## Technical Memorandum

### Great North Road Solar and Biodiversity Park: Issue Specific Hearing 3 - Action; Clarification of Landscape Character Assessment and Cumulative Effects

Cumulative Effects with One Earth Solar Farm
Figure 7.8

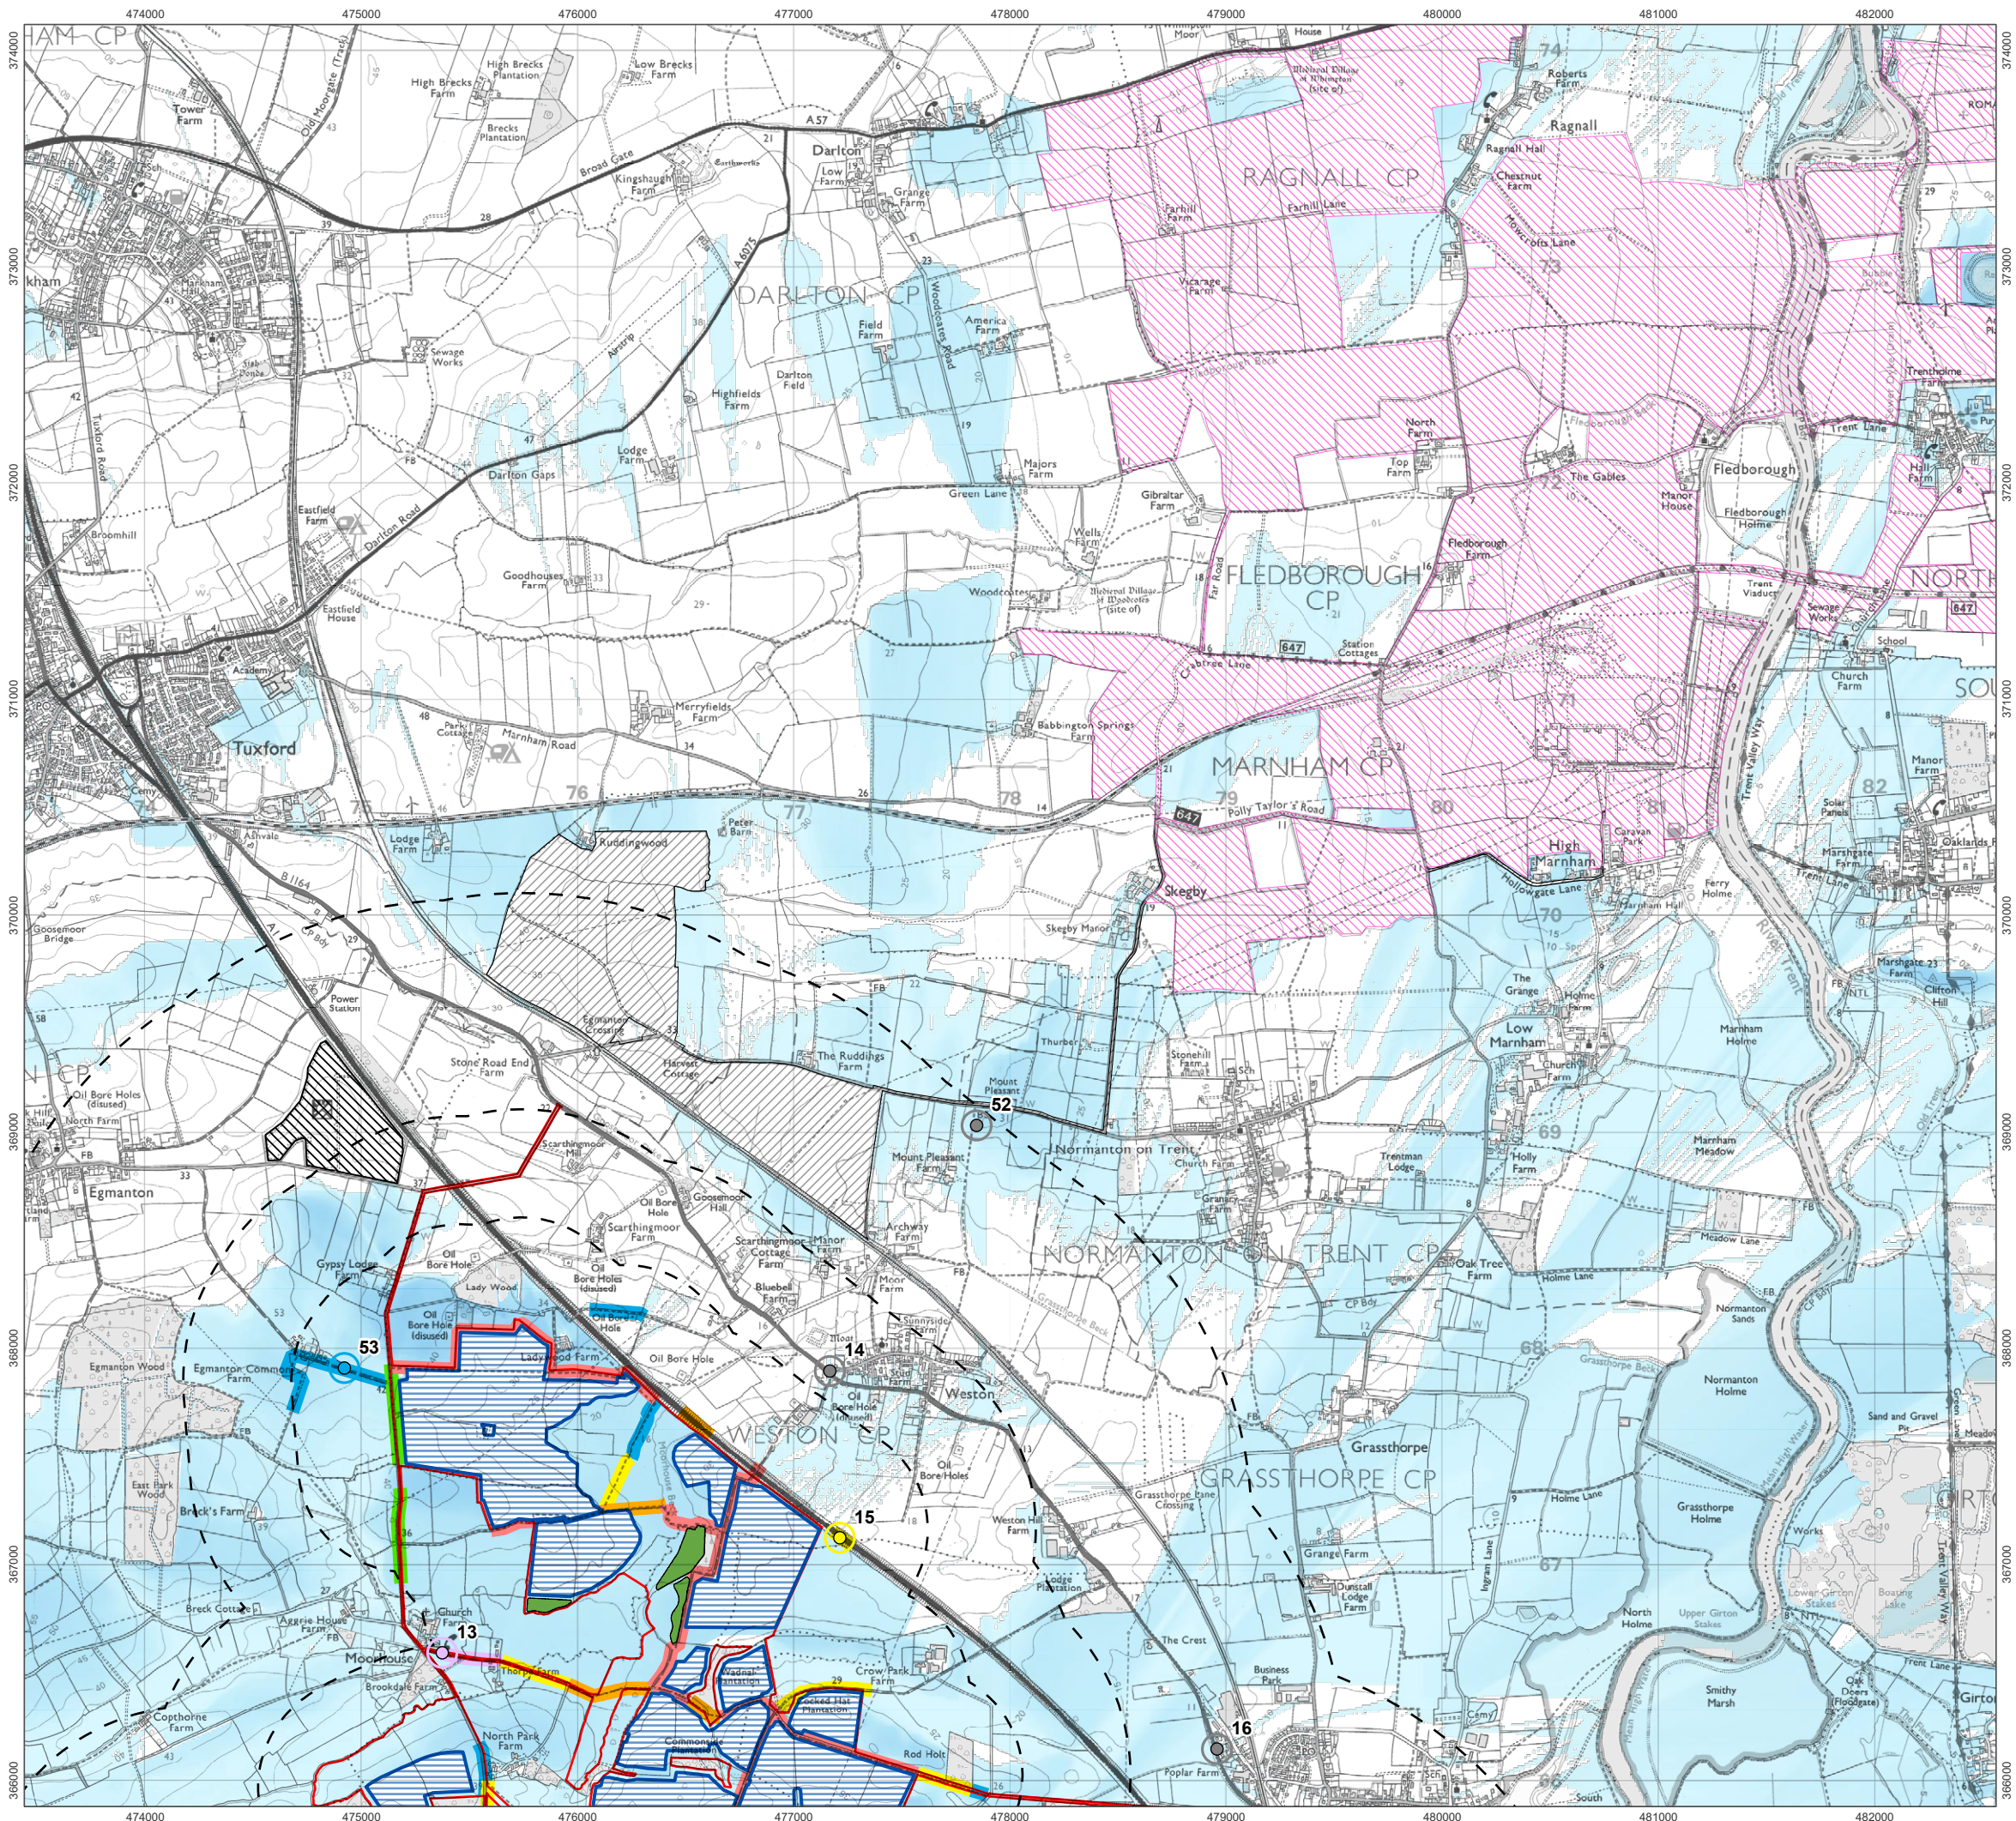
These sequential cumulative visual effects are more likely to be experienced in conjunction with the One Earth Solar which is located north of the Great North Road.
